ENG-SF22035-R1-CDs-GEC.pdf Markup Summary

SF-22-035

DESIGNED BY MES SCALE DATE 08/31/22
DRAWN BY MES (H) 1" = 50' SHEET 6 OF 53
CHECKED BY (V) 1" = N/A JOB NO. 1183.30

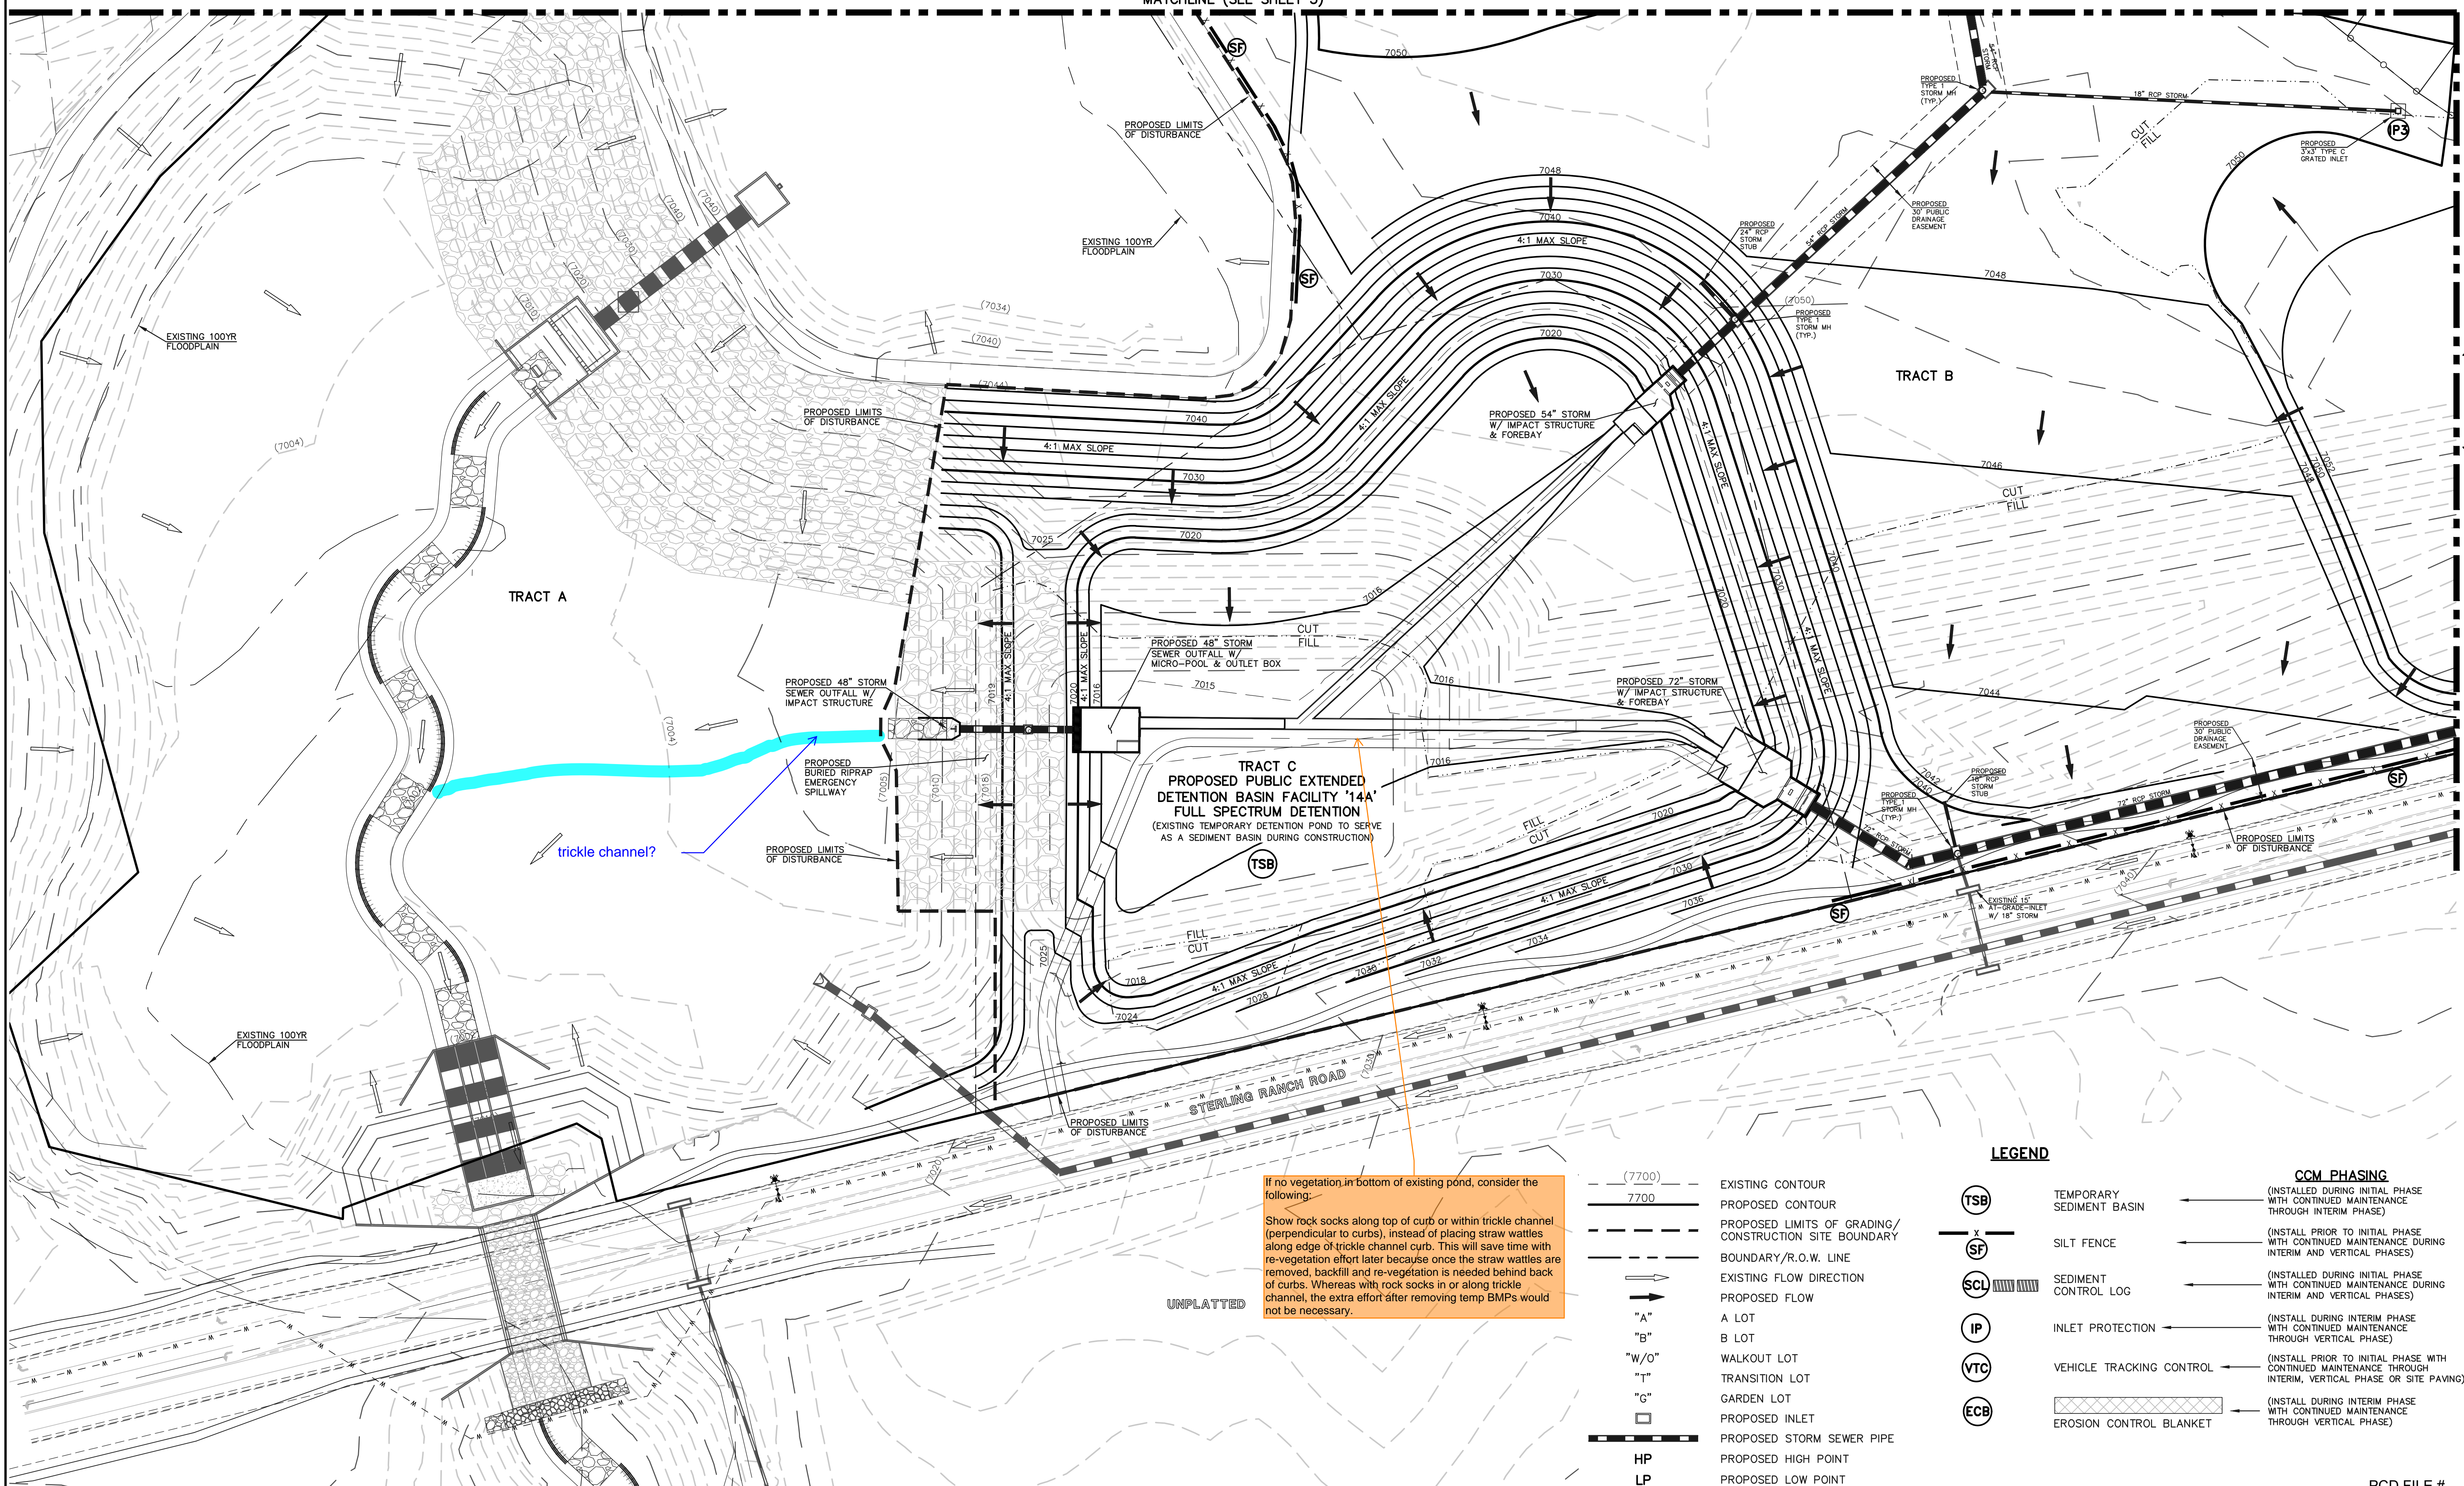
Show all sump inlet ponding areas and elevations

| DRAWN BY | MES | (H) 1" = 50' | SHEET | 42 OF 53 |

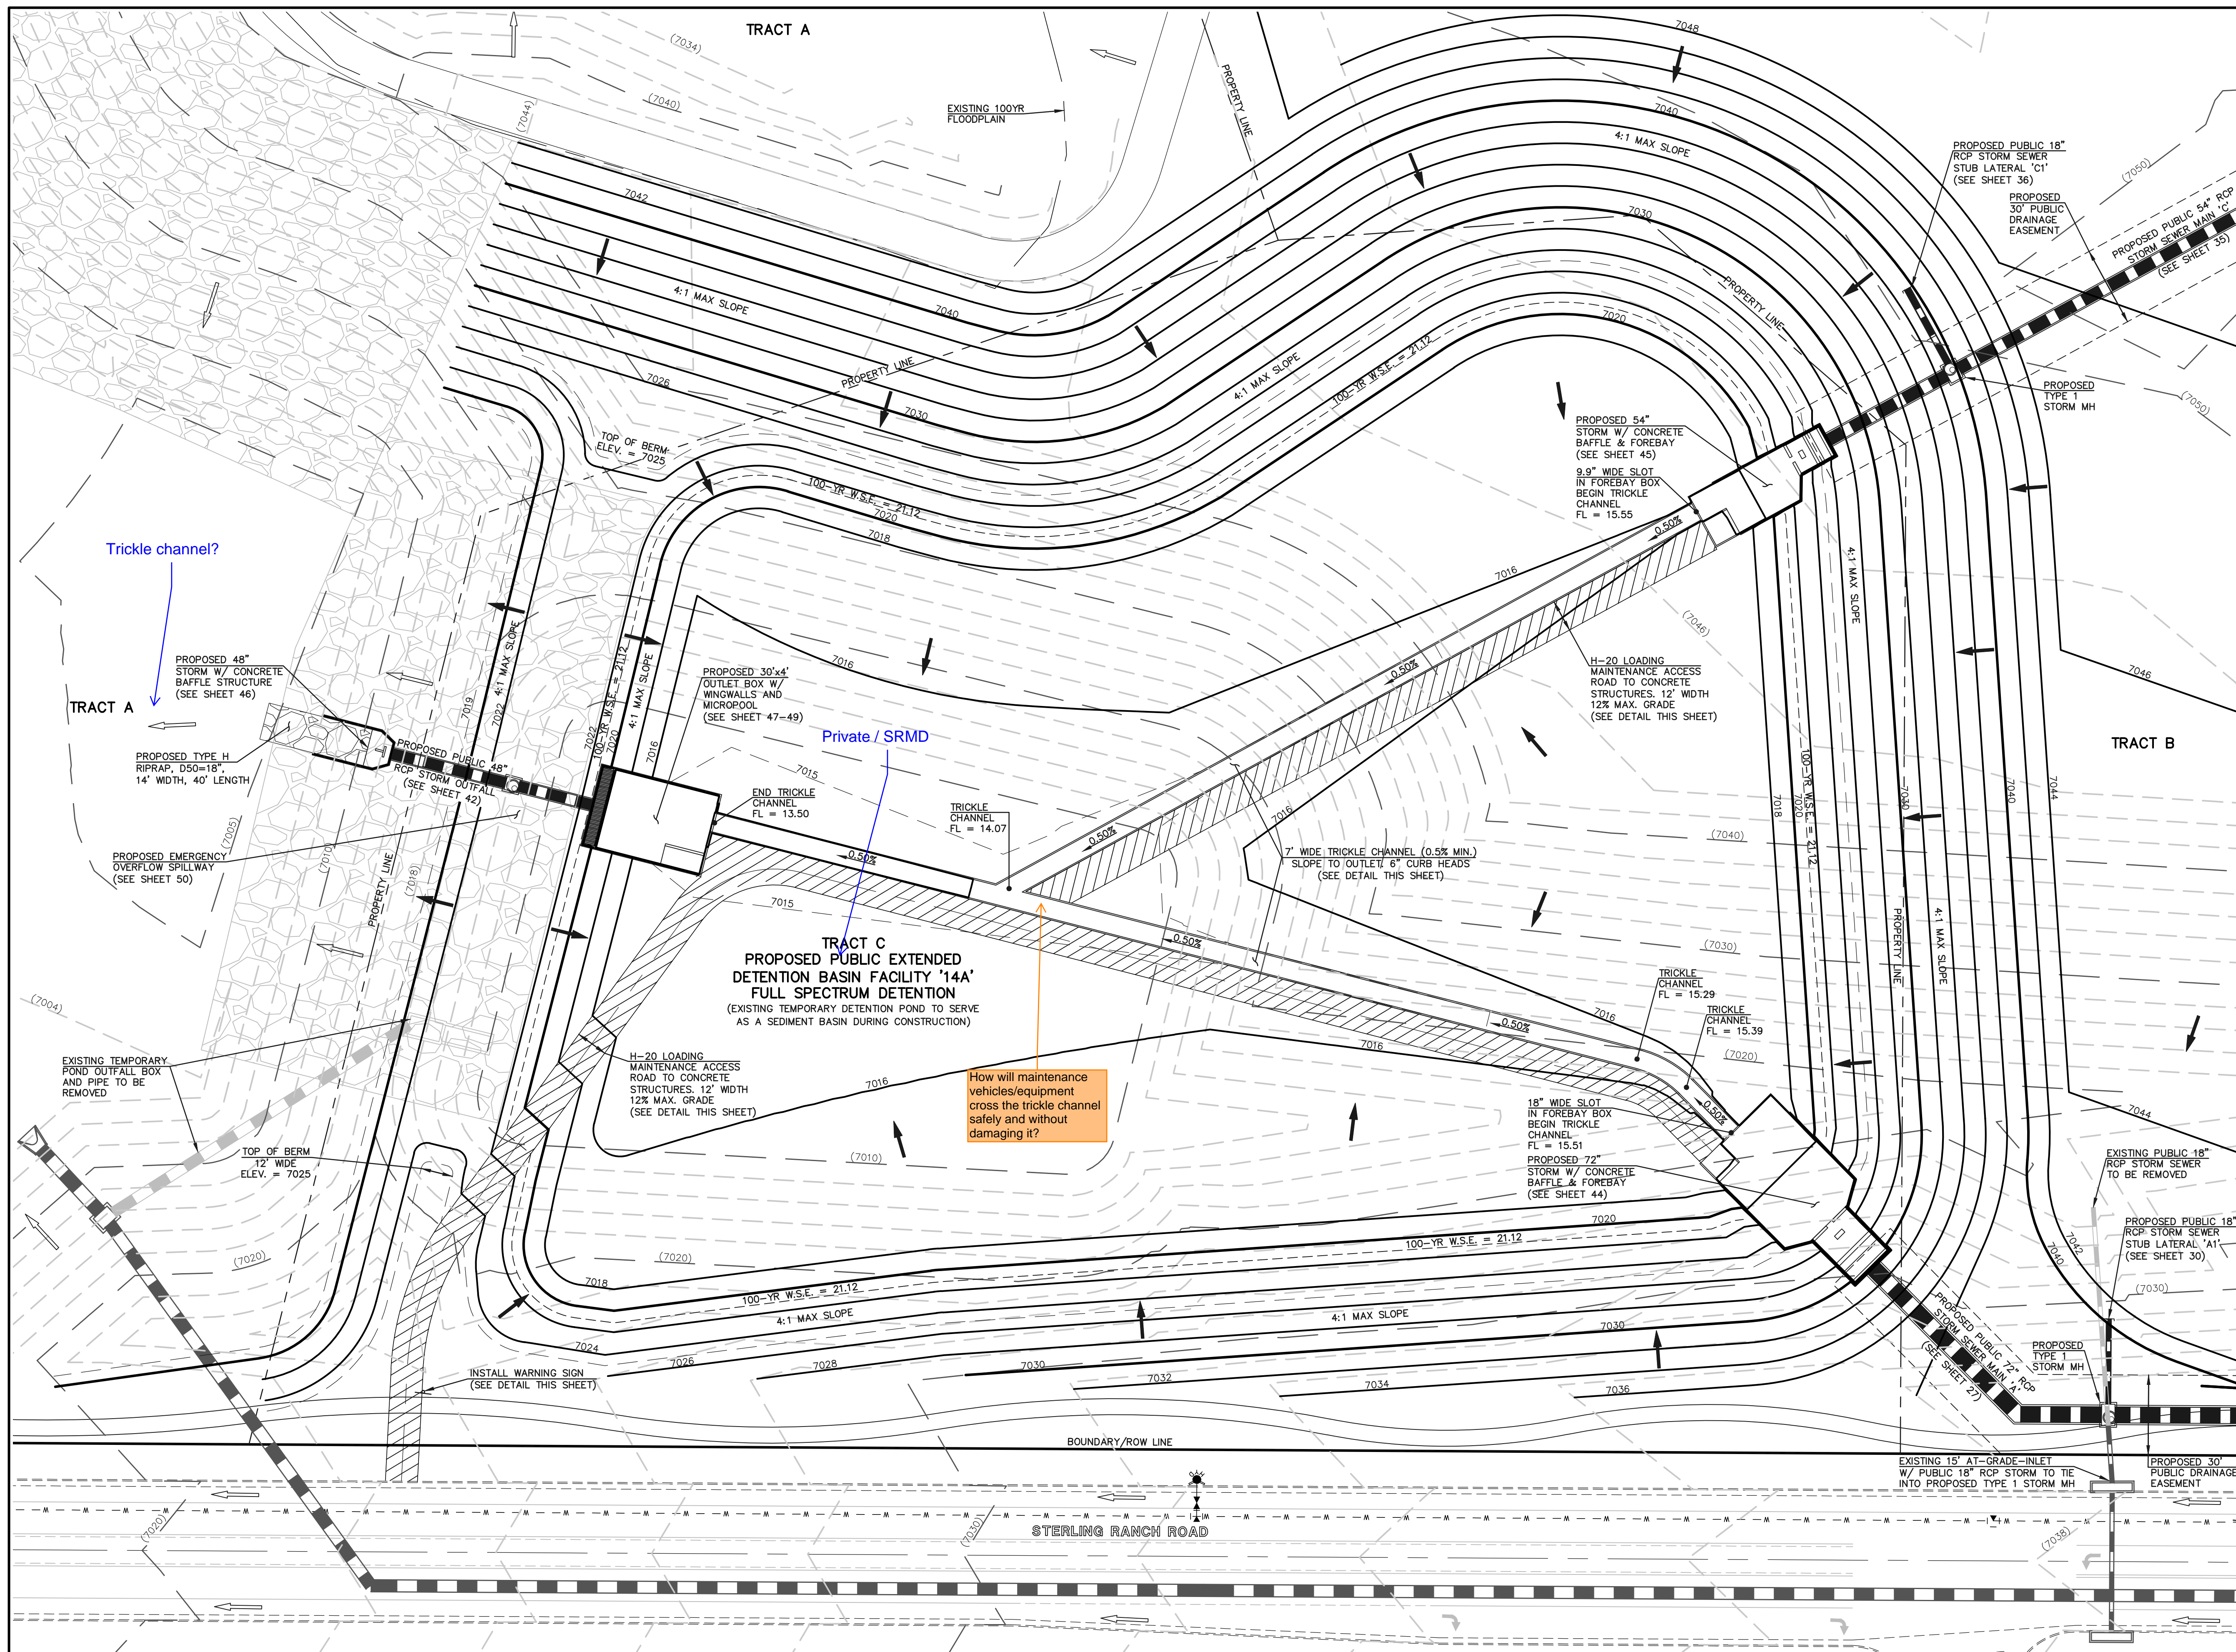
Trickle channel?
